Ribble Valley Borough Council
Housing & Development Control

Your ref: 3/2023/0573
Our ref: D3.2023.0573
Date: 10th August 2023

Application no: **3/2023/0573**

Proposal: **Proposed industrial unit.**

Proposed Site Plan 1:200

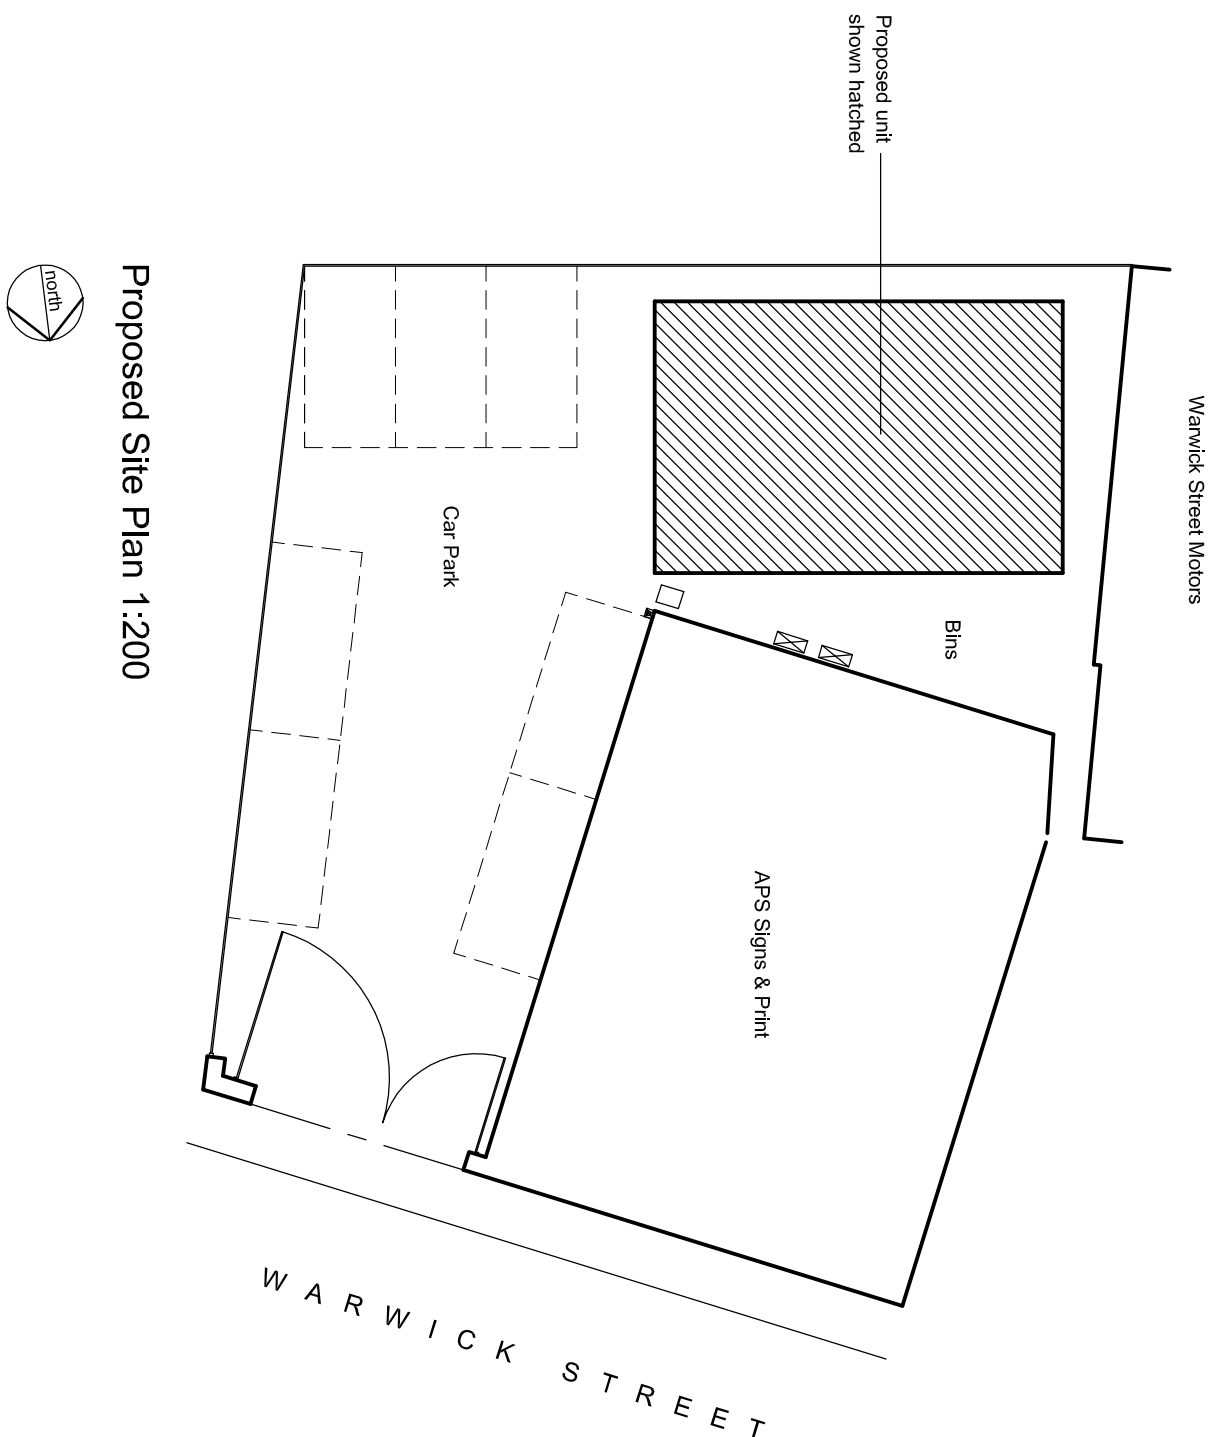
The LHA have reviewed David Haworth drawing number 1538/01 titled "Proposed Industrial Unit" and are aware that the site will utilise an existing access which serves the existing commercial unit. The LHA have reviewed the access width and are aware that the access is approximately 5.8m wide. For the site to comply with the LHAs guidance, the LHA require the access to be a minimum of 6m wide.

The LHA would also request that the gated access is setback a minimum distance of 10m behind the highway boundary, following the intensification of use. This could be reduced to 5m depending upon the size of vehicles which service the existing and proposed unit.

The LHA have reviewed David Haworth drawing number 1538/01 titled "Proposed Industrial Unit" and following the erection of the proposed unit, the LHA have concerns regarding where the proposed and existing unit will be serviced from. This is because following the proposal, there is limited space for servicing vehicles to turn around and exit the site in a forward gear.

However, as part of this proposal, this area will be removed meaning that there is no designated servicing facility for not only the existing unit but also the proposed. This could mean that should servicing vehicles refuse to enter the site, due to them not being able to turn around internally, then both units will be serviced from the street.

Even if servicing vehicles enter the site, should there be no available space on-street, as already mentioned, there are no turning facilities internally to exit the site in a forward gear. Therefore, large servicing vehicles will be expected to reverse out of the site. However, this would be to the detriment of highway safety with vehicles parking on-street not only providing an obstruction to the reversing movement potentially creating conflict points but also parked vehicles obstructing the access's visibility splays, meaning that conflicts could occur should other vehicles be using Warwick Street at the same time as the movement. As a result of the potential conflicts, allowing this area to be used will be to the detriment of highway safety and contrary to paragraph 111 of the NPPF (2021).

The LHA have further reviewed David Haworth drawing number 1538/01 titled "Proposed Industrial Unit" and are aware that the existing and proposed site are proposing to provide 7 car parking spaces, which will be shared by the existing and proposed units.

Unfortunately, the LHA are unwilling to formalise the area with 4 of the spaces being deemed unusable due to there being inadequate turning facilities internally and two of the spaces potentially conflicting with each other. Therefore, the site can only provide 3 car parking spaces, which are deemed safe and suitable for the two units.

The LHA do not have any details regarding the internal floor area of the existing unit or its parking demand, but the LHA are able to determine that the parking demand for the existing unit will be more than one car parking space. Therefore, following the proposal there will be a shortfall in parking at the site.
